RE: ESTRADA OFFICE BUILDING (J13-D48)

RE: DRAINAGE PLAN FOR ESTRADA OFFICE BUILDING  
(J-13/D48) ENGINEER'S STAMP DATED SEPTEMBER 7, 1990

REVISED
GRADING AND DRAINAGE PLAN
FOR
A PROPOSED OFFICE BUILDING LOCATED AT
609 12TH STREET N.W.
ALBUQUERQUE, NEW MEXICO
AUGUST, 1990
(REVISION: 09-07-90)

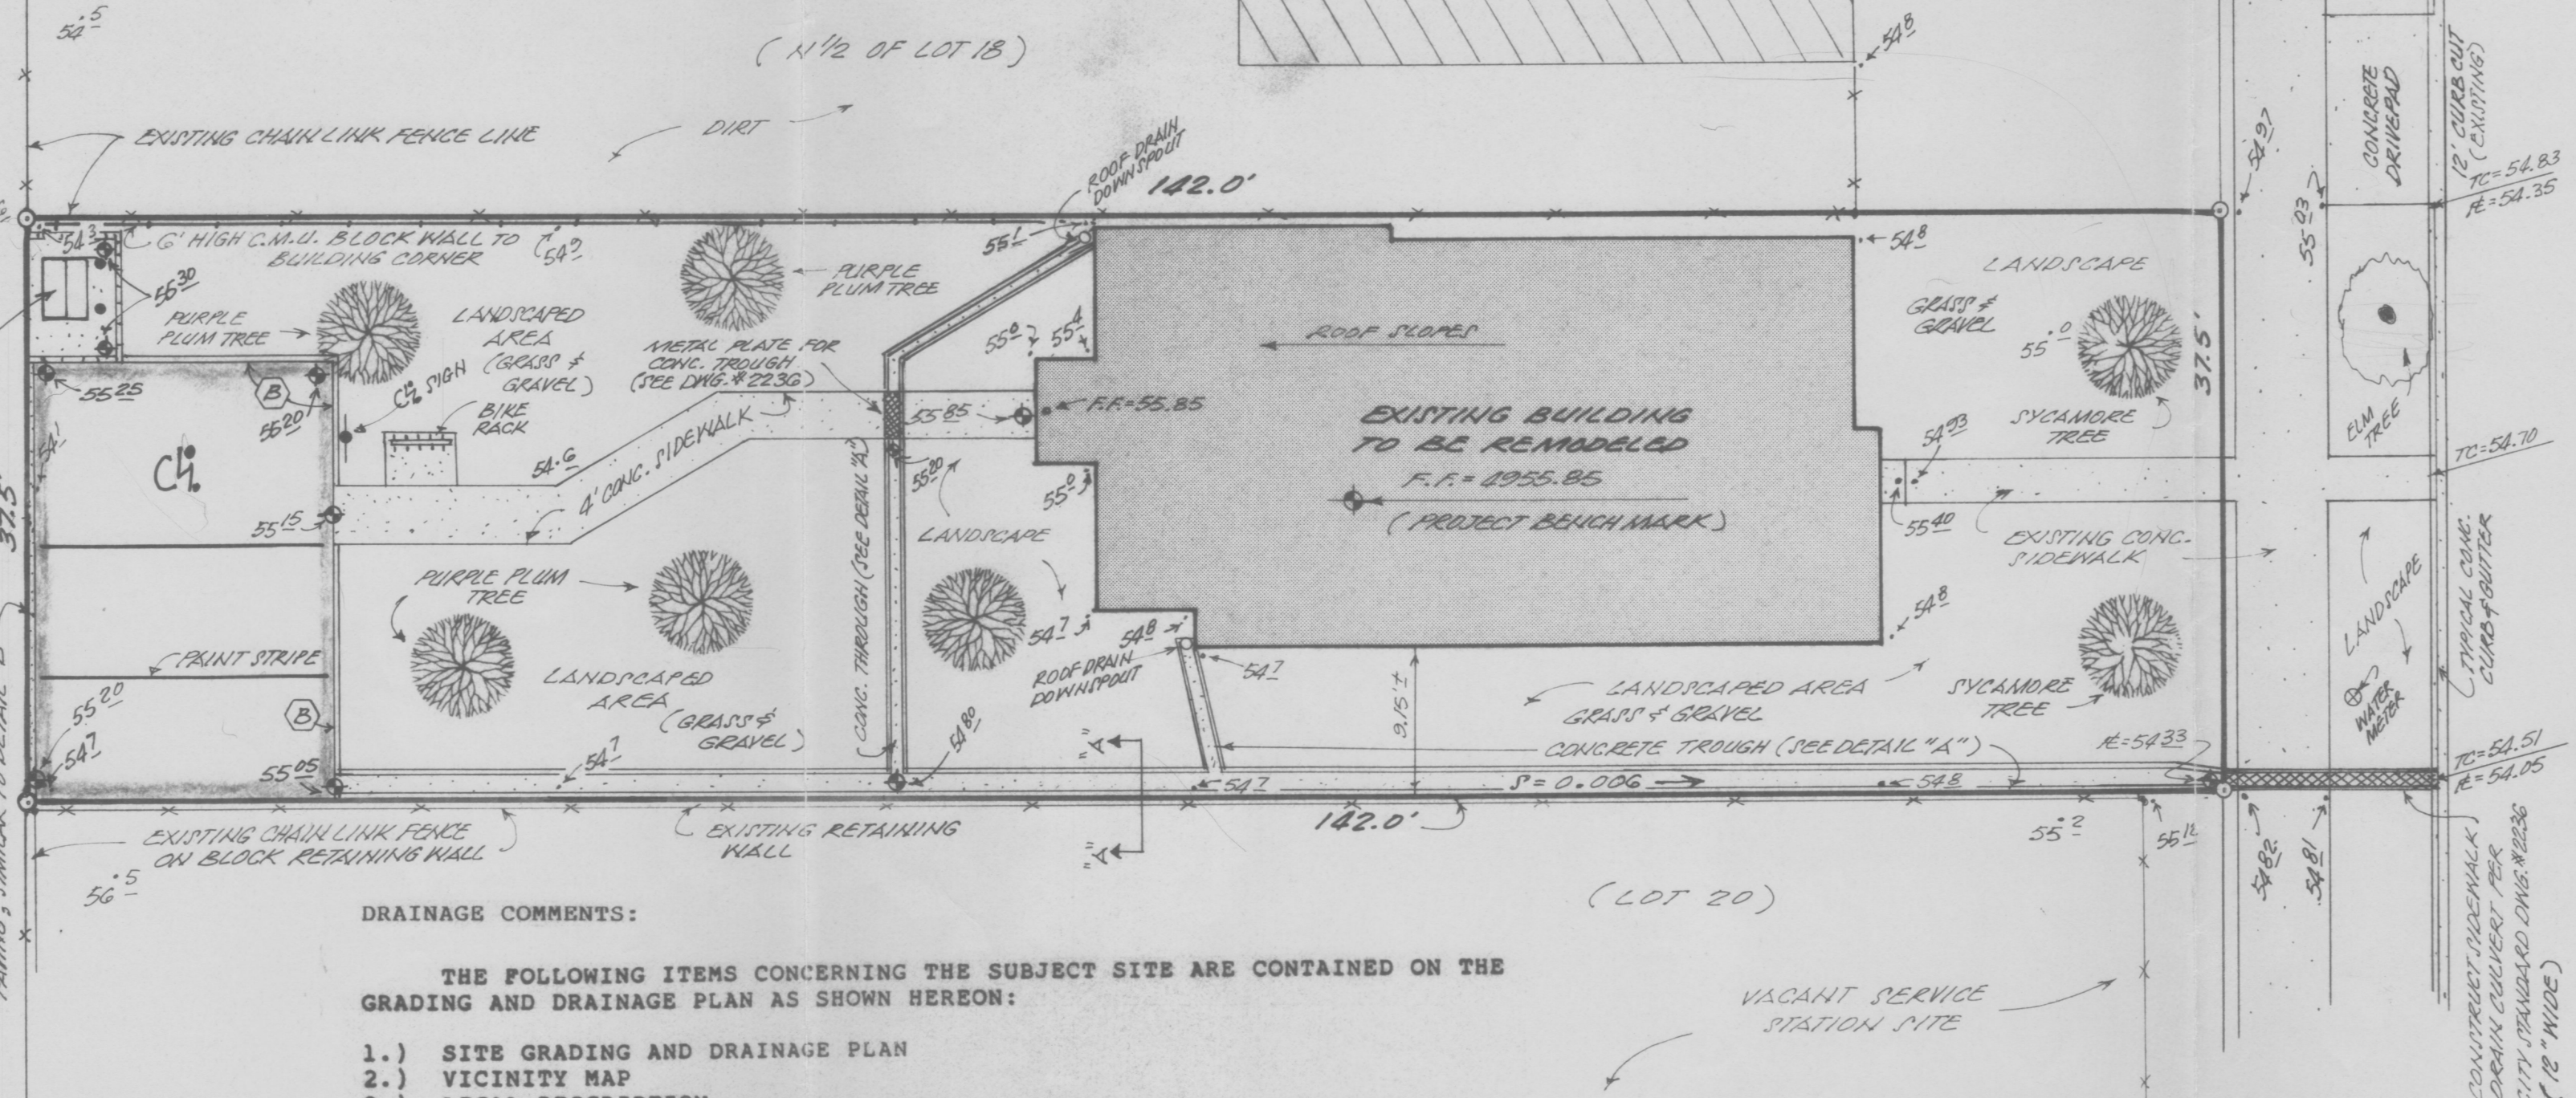
As of January 1, 1998, you will be allowed until January 31, 1998 to complete and certify the site. If the construction is not completed by the allowed time, the original requirement of approved alley grades and permanent alley improvements will be imposed.

1. Asphalt millings will be placed on the alley with positive drainage towards Lomas.
2. All developed run-off will be routed to 12th Street.
3. Engineer Certification after completion of project.

Please be advised that the Certificate of Occupancy will not be released until the following have been addressed:

1. Approved alley grades from DRC along with the construction specifications for the alley.
2. Alley improvements must be in place.
